HEALTH DEPARTMENT COMMENT RESPONSE LETTER

DATE: March 24, 2023
PROJECT ARCHITECT: ELEVEN18 ARCHITECTURE, PL
CONTACT NAME AND NUMBER: Matt Conte, 407-745-5300

PROJECT NAME: The Springs of Ballentine
PERMIT NUMBER: N/A
PROJECT NUMBER:
FID NUMBER:

PLEASE NOTE THE FOLLOWING REVISIONS TO THE PROPOSED SET OF DRAWINGS HAVE BEEN COMPLETED IN RESPONSE TO THE NORTH CAROLINA DEPARTMENT OF THE HEALTH DEPARTMENT COMMENTS.

**A201**  
 OVERALL FLOOR PLAN

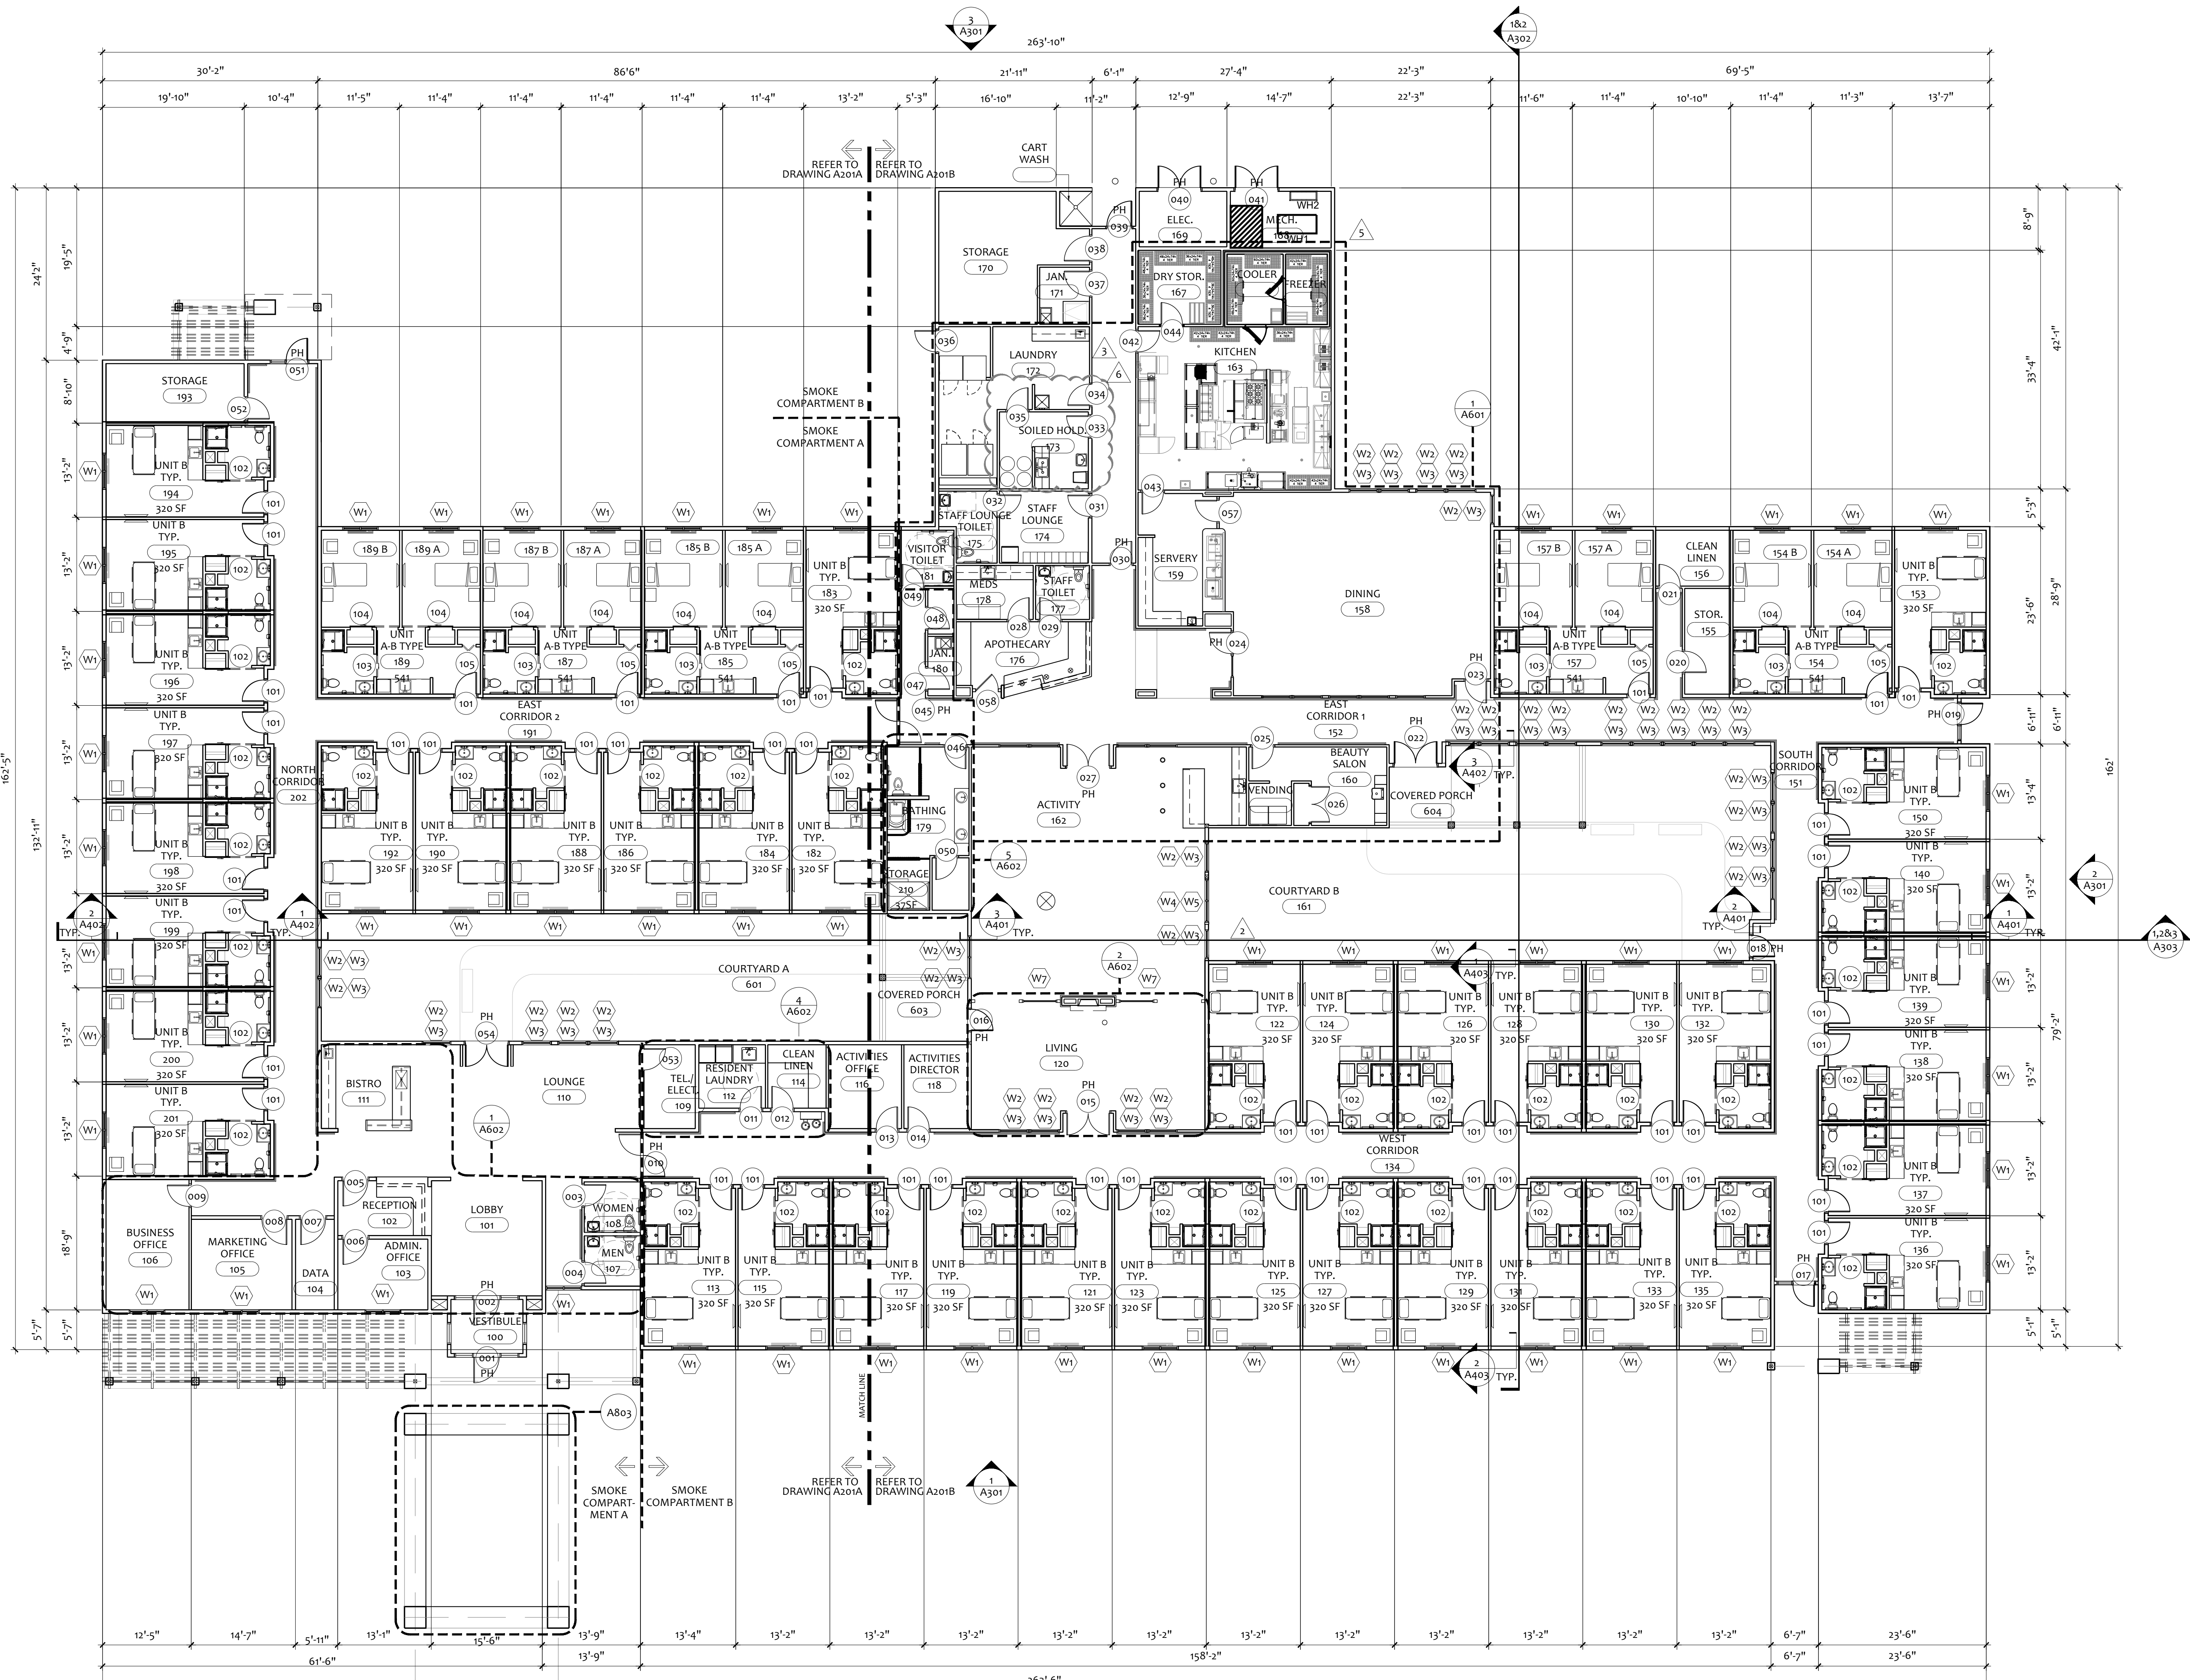
1. COMMENT: Indicate the intended use of the sink in the clean linen area of the laundry room. Additional hand sink to be added to the laundry area #172 on the plans as discussed. To be provided on revised plan

RESPONSE: Sheets A201, A203, A601 and A606-2 have been updated to show the addition of a hand sink in the laundry area #172.
